Sunnica Industrial Solar Site

I understand you are coordinating Natural England's response to the Sunnica Industrial Solar Site (SISS). I am part of the Say No To Sunnica Action Group (SAG) and a neighbour and local farmer next to the scheme. We would be very grateful for your help on two matters:

ALC Soil Classification – as you know Sunnica submitted with their ES report produced by Daniel Baird Soil Consultancy Ltd (DB). This concluded that in the 981 ha site there was only 3.8% of BMV land. The report omitted the cable route. Natural England have taken this to be correct and based their response to the scheme on this premise. SAG do not believe this is correct for the following reasons:

Sunnica Energy Farm Proposed Layout - (Predictive BMV Land Assessment)

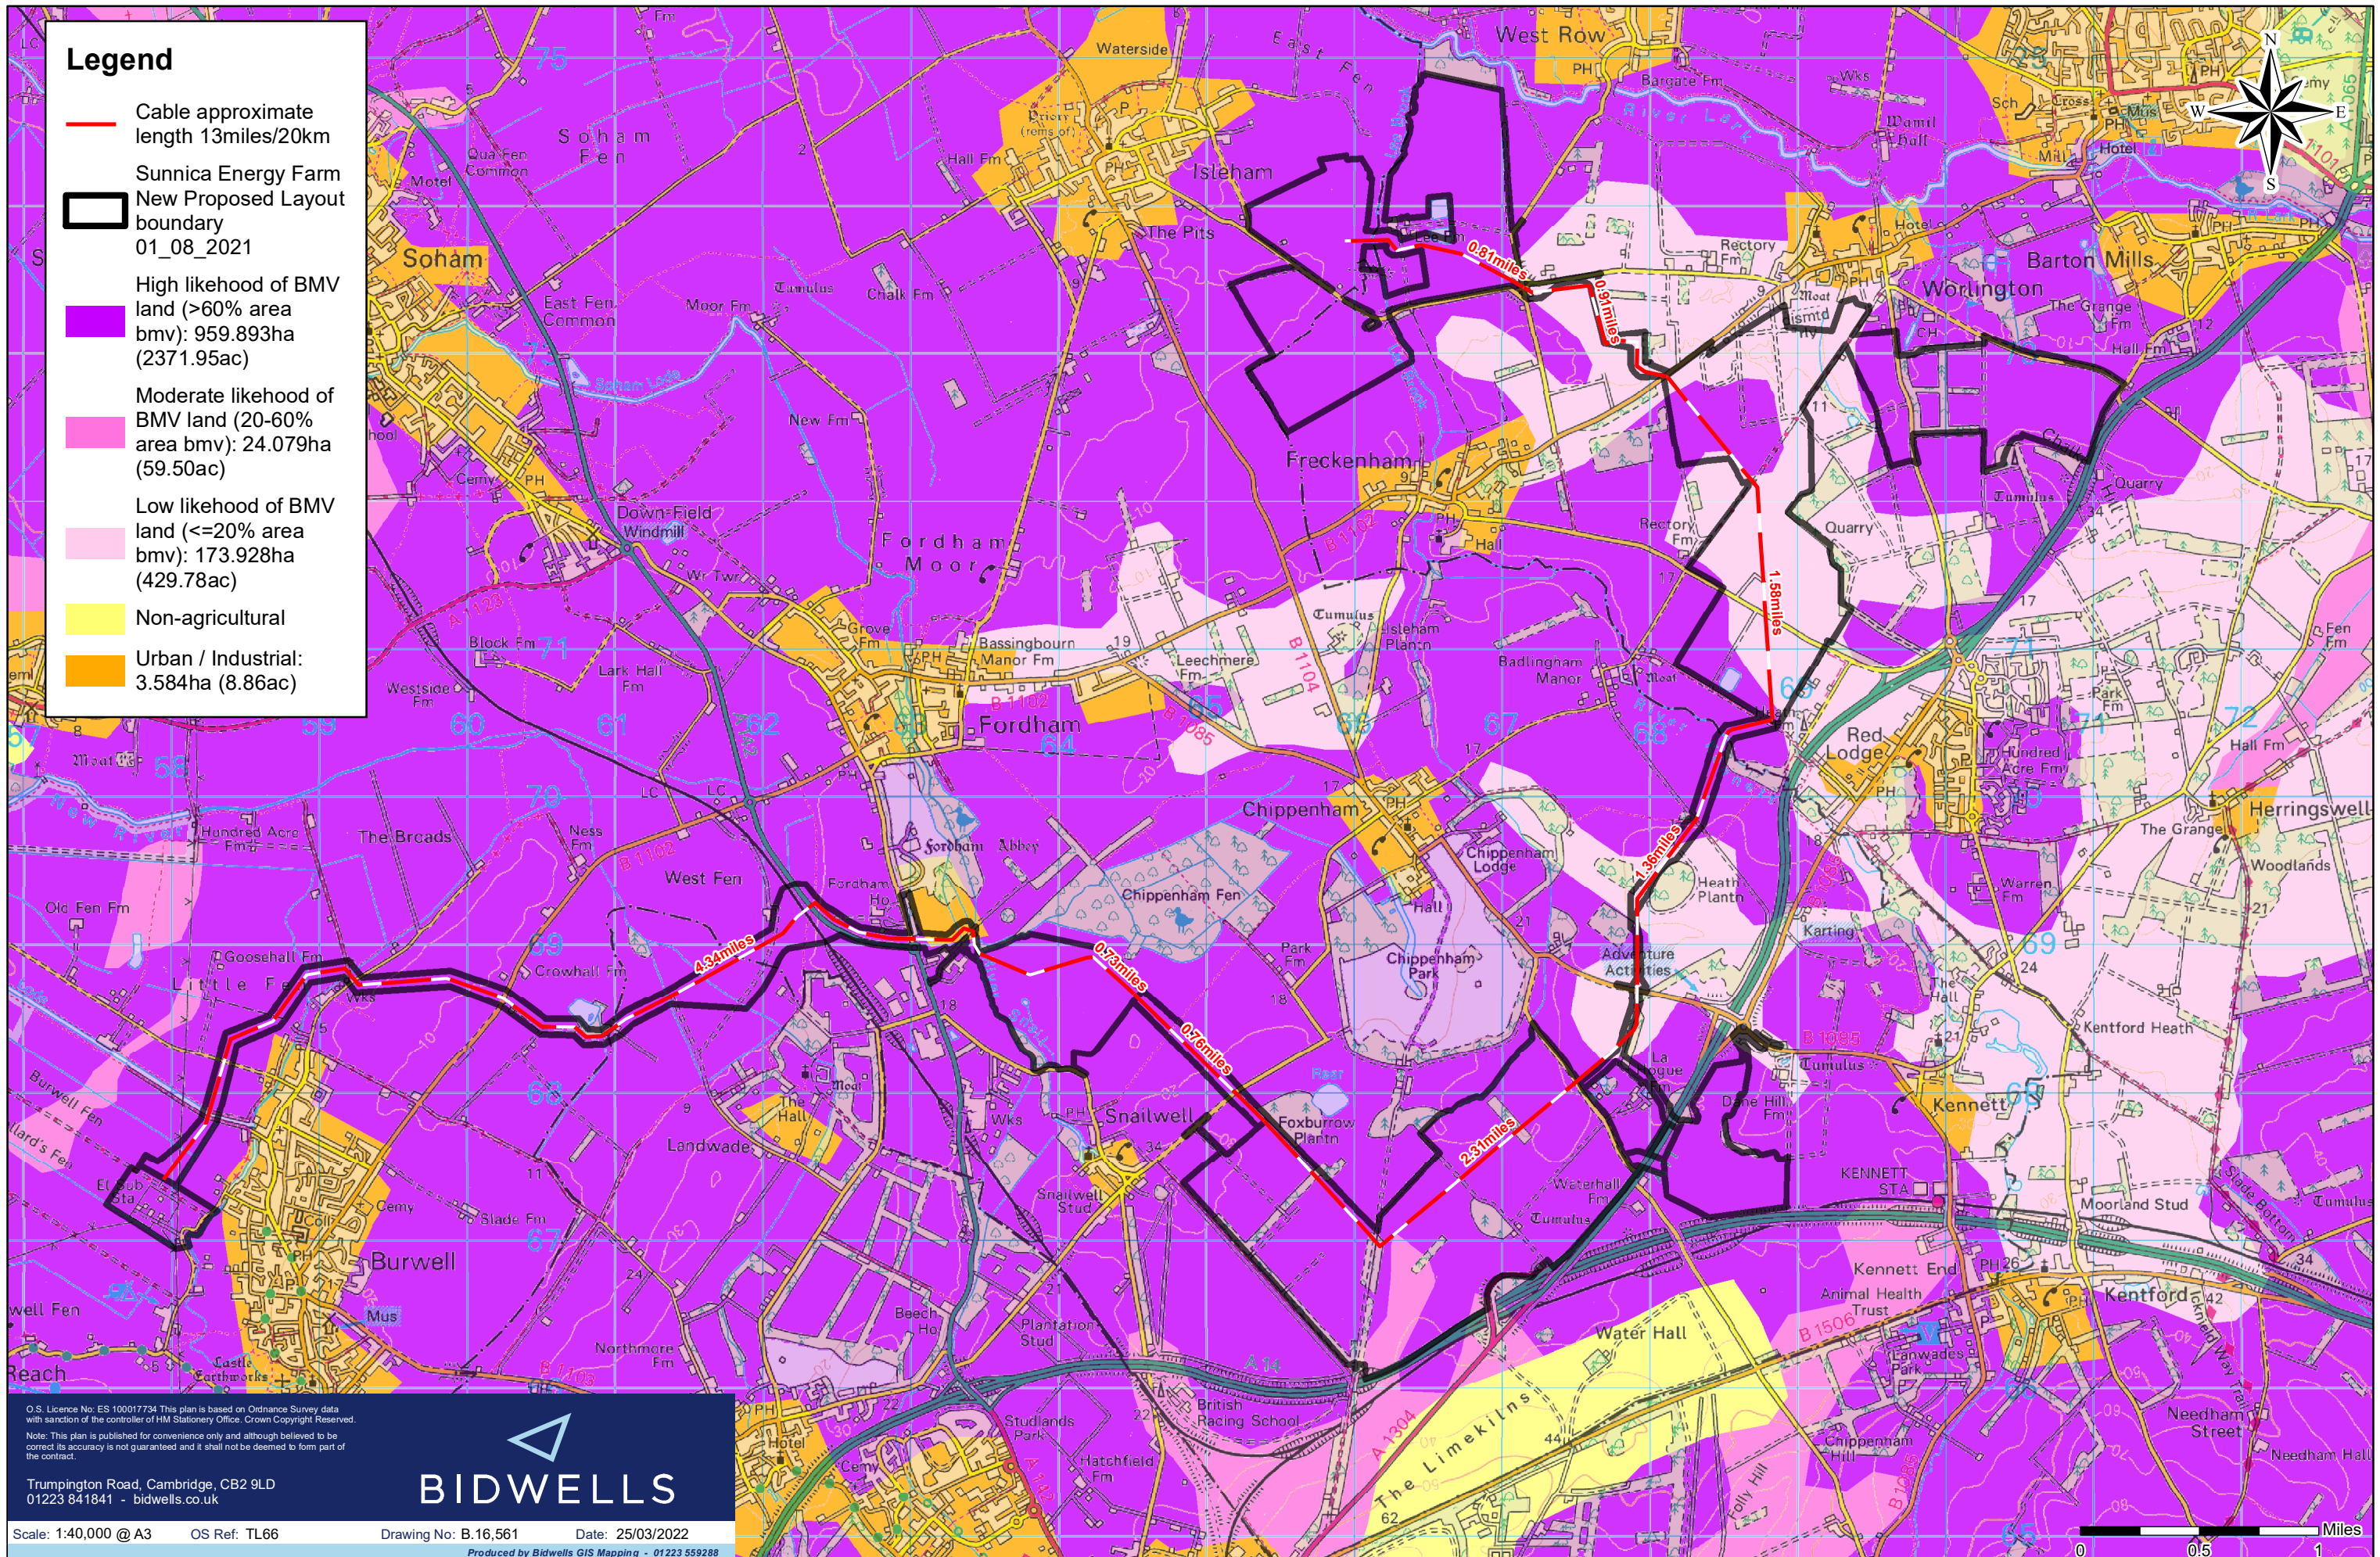
Plan 2 – Produced by Natural England - including the cable route.

a/ this shows that 960 ha of the site is 60% or more likely to be BMV.

b/ the total area within the boundary is 1,162 ha – therefore 83% of the site is 60% or more likely to be BMV.

c/ this would give an overall of 50% BMV on the site. $960\text{ha} \times 60\% = 576\text{ha}$ is 50

Both plans show a considerable difference to DB. Natural England's own work shows 50% BMV.
